State of Washington
DEPARTMENT OF FISH AND WILDLIFE
South Central Region • Region 3 • 1701 South 24th Avenue, Yakima, WA 98902-5720
Telephone: (509) 575-2740 • Fax: (509) 575-2474

July 1, 2024

SUBJECT: WDFW COMMENTS ON SD-24-00001/CU-24-00005 RED'S FLY SHOP

1 SITE PLAN
SCALE: 1" = 20'-0"

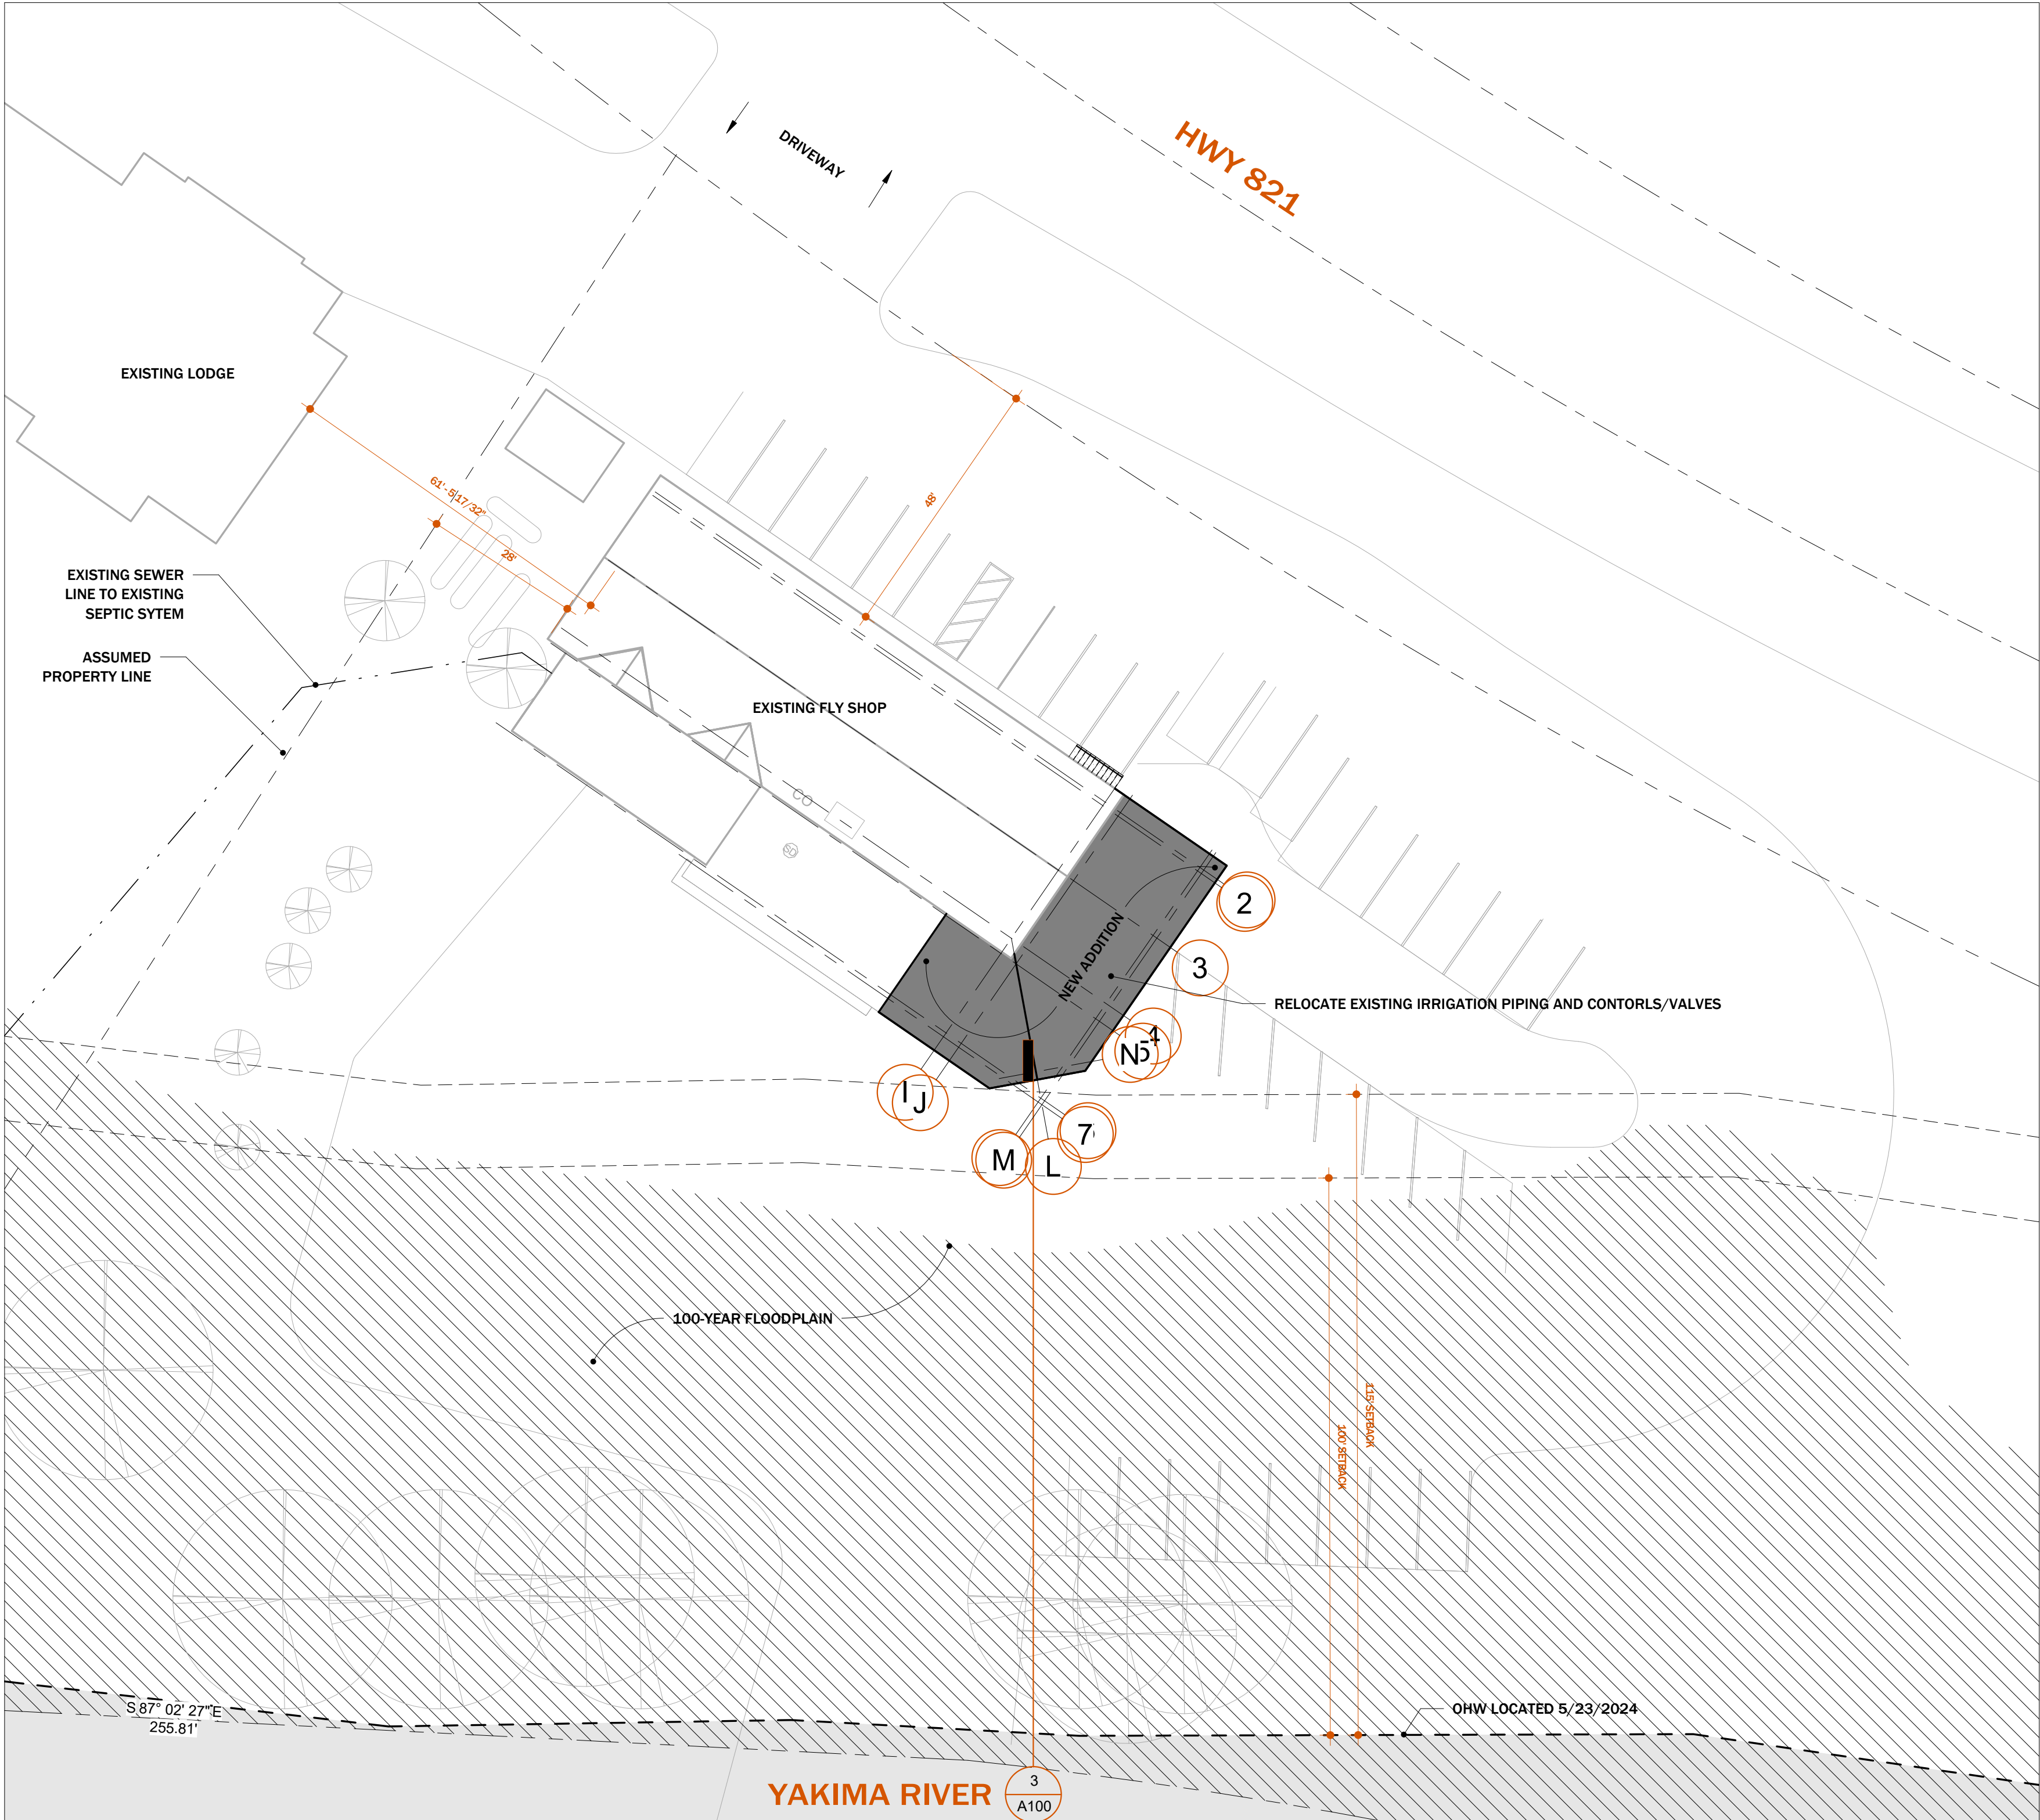
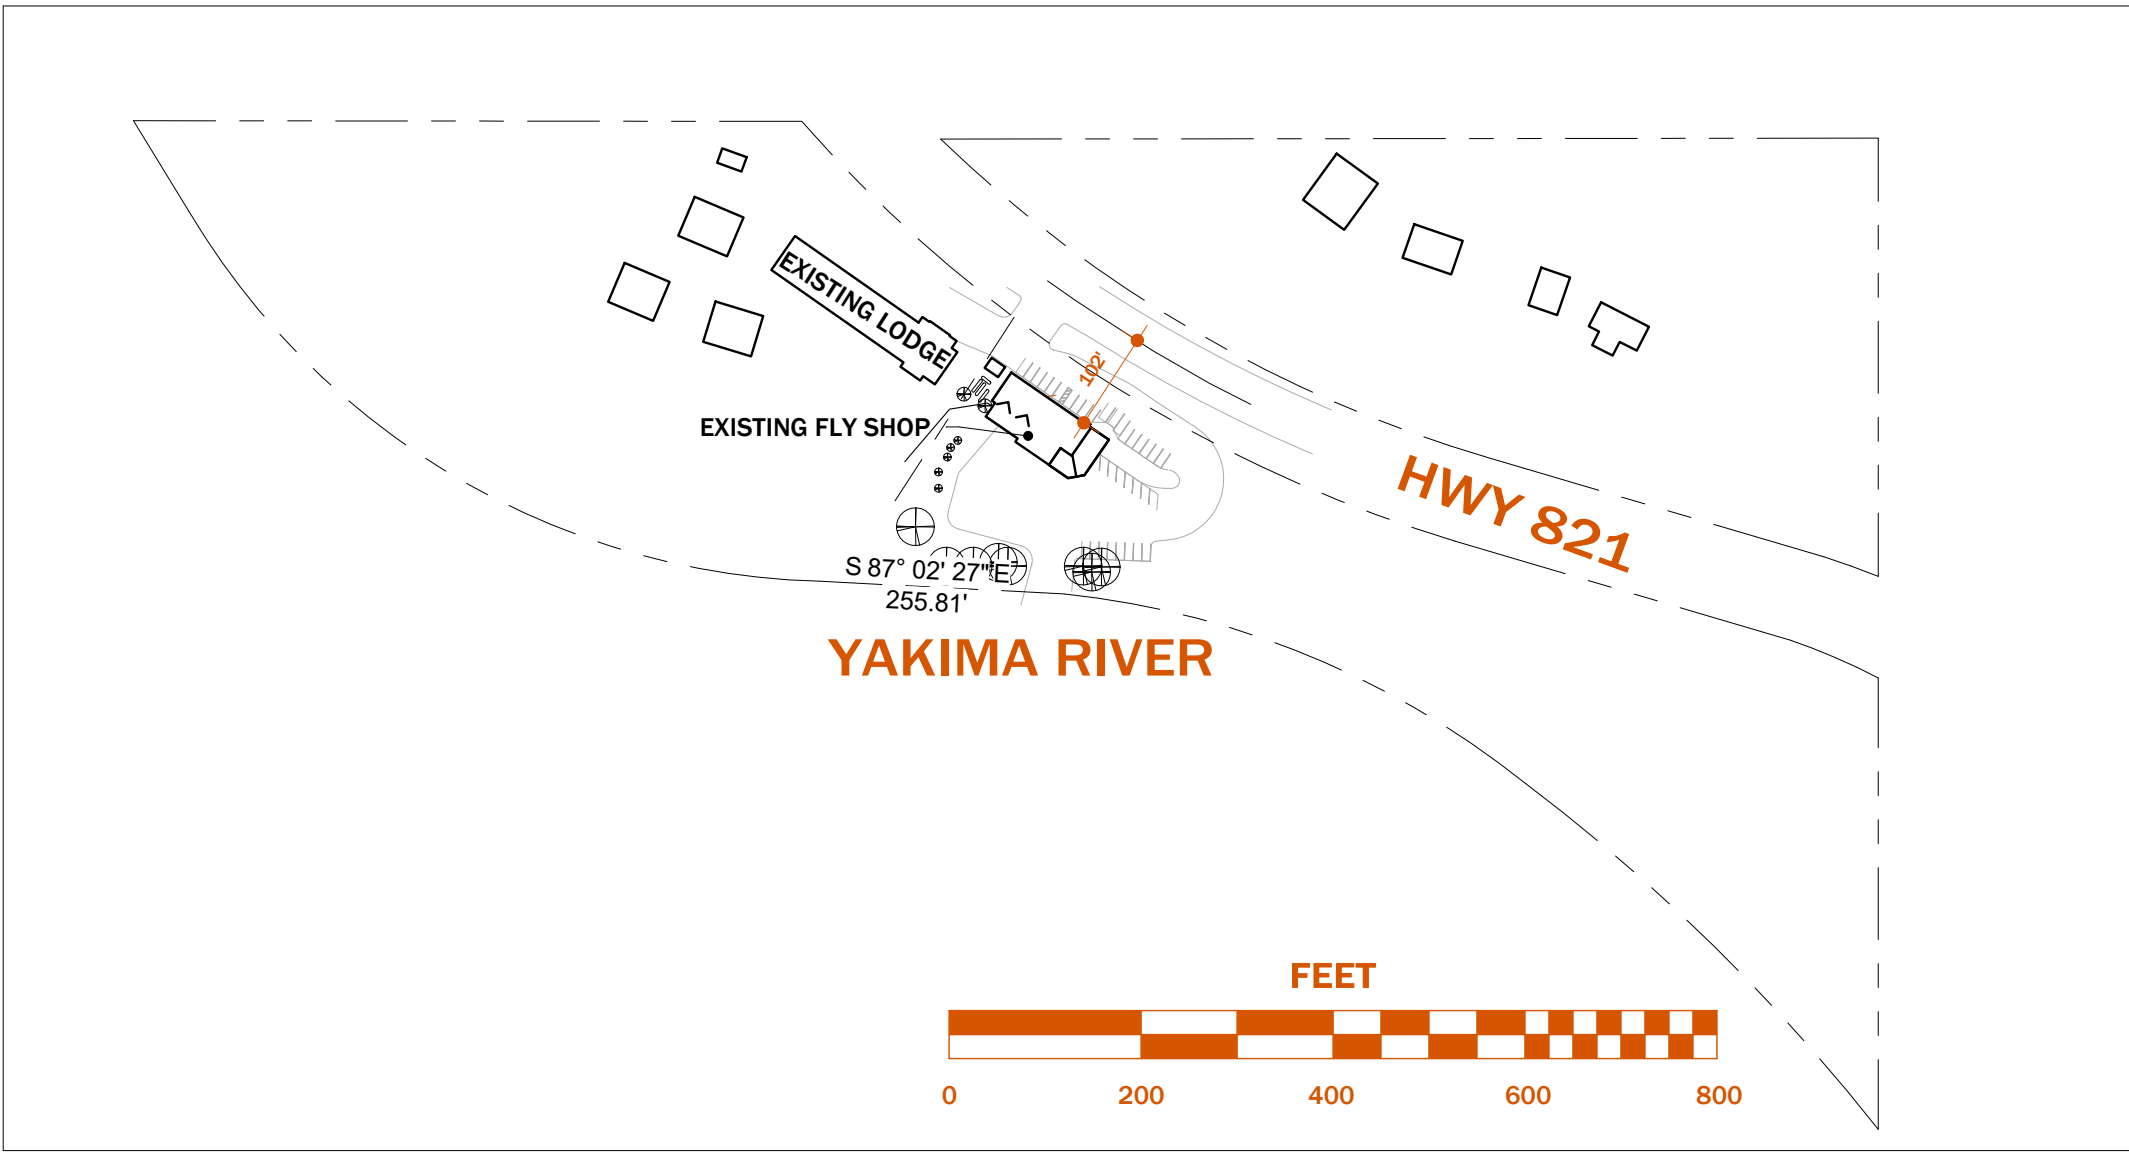
The Yakima River Canyon, and this specific parcel, are identified as a Biodiversity Area and Corridor (BAC) in WDFW's Priority Habitats and Species (PHS) Program. Ensuring this BAC provides a diversity of habitat types for wildlife cover and shelter is important for its overall function as a migratory corridor. The critical areas present on the parcel have not been identified in the existing materials available for review. We appreciate that the footprint of the project will be an addition to an existing building and the building footprint will be at least 100 feet from the ordinary high-water mark of the Yakima River; these measures will help minimize impacts to surrounding habitats.

Because the project area falls within a BAC and there will be a temporary and long-term increased risk of runoff to the Yakima River and the fish life in it, **we recommend additional riparian plants along the Shoreline within the parcel in addition to BMPs during construction.** WDFW would welcome the opportunity to complete a site visit with the County and/or project proponents to identify areas where additional shoreline vegetation would benefit the river and be compatible with the overall uses on the property.
